From: [Ronni Marie Collins](#)
To: [Chace Pedersen](#); laura.osladacz@co.kittitas.wa.us; mark.good@co.kittitas.wa.us; [Jamey Ayling](#)
Cc: [Ronni](#)
Subject: Manastash Cell Tower Proposed Site Objection
Date: Wednesday, August 23, 2023 12:45:33 PM
Attachments: [5G Neighborhood flyer rev 8-22.pdf](#)

I recently became aware of an application from Atlas Tower1, LLC to build a 100 ft. tall cell phone tower off Manastash Road at Blazing Sky Lane. This tower is proposed to be erected on the rural property of Victor Strand – this property is zoned residential and in the heart of the west side of Ellensburg a very desirable living area and very near where my family lives, and where we have community with our neighbors.

TOWER ELEVATION

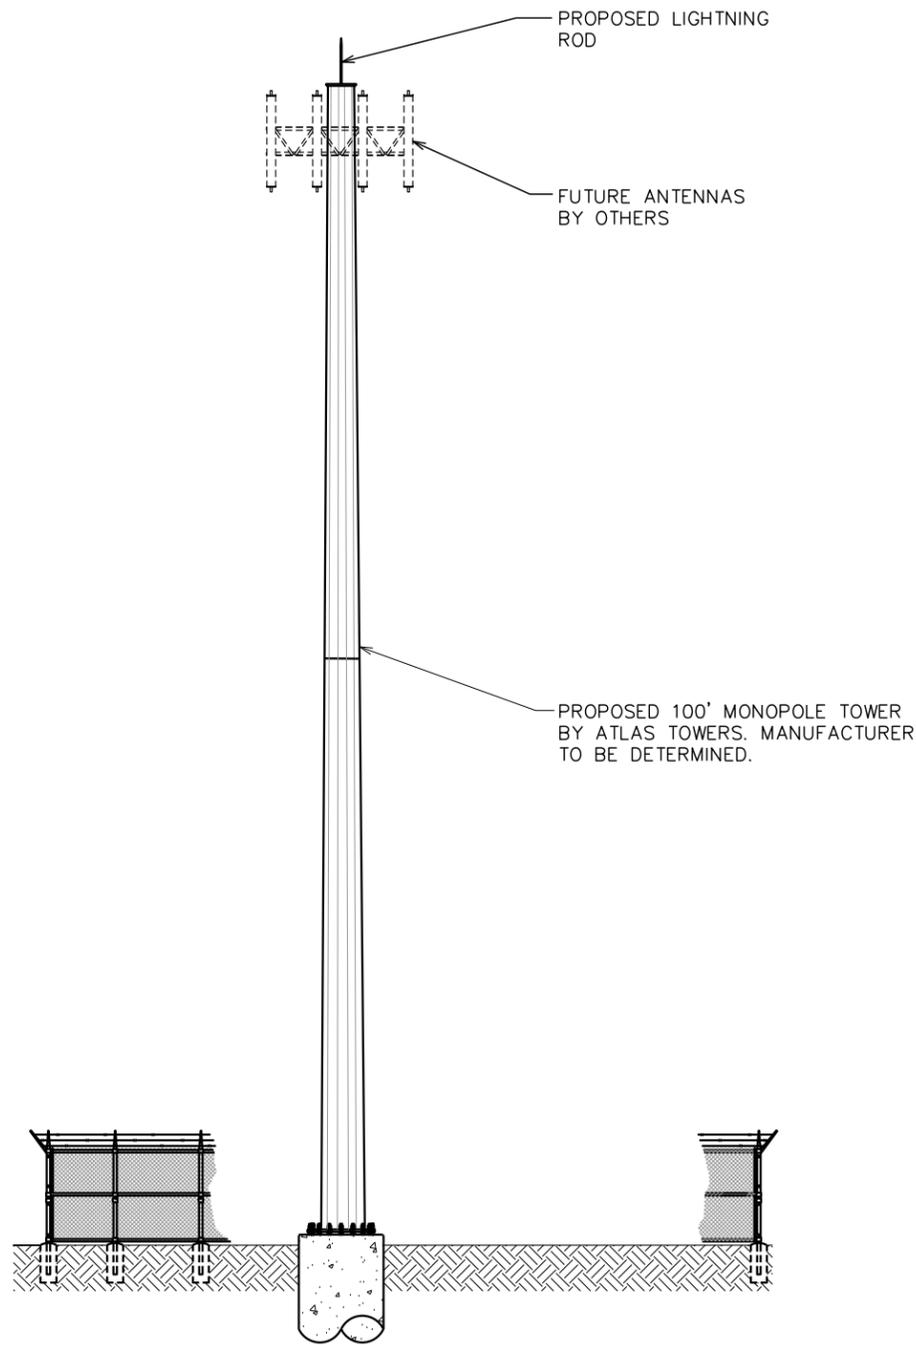
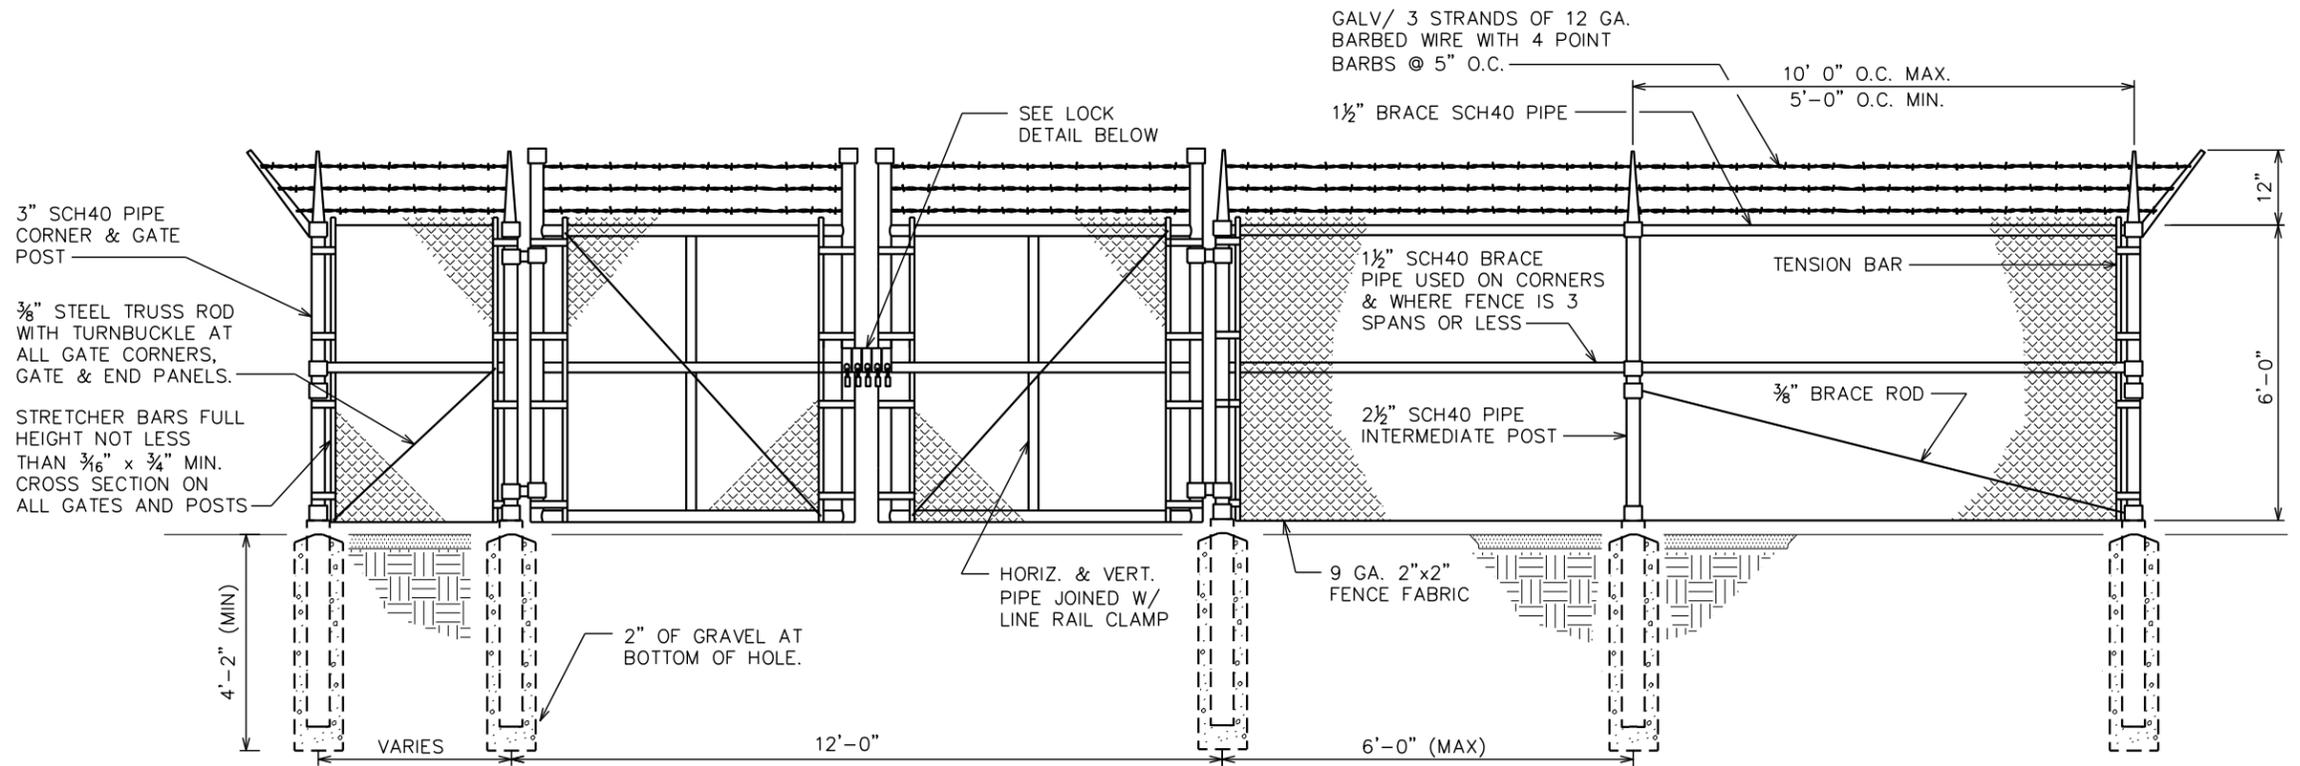
A 100 ft. galvanized cell phone tower (per Atlas site plan) is a complete disruption within this community. Atlas, a Colorado company, I suggest has never visited the actual site because if they did, they would not be able to truthfully state that the site was chosen to maximize visual aesthetics. This tower is in the heart of our community and would be unsightly from many distances North, South, East and West of its proposed location. It does not follow Kittitas own plan – it does not support or preserve our rural lifestyle. Of note, this west valley is flat farmland and butts up directly to the mountain ranges therefore you would see this 100 ft galvanized tower from every height and angle.
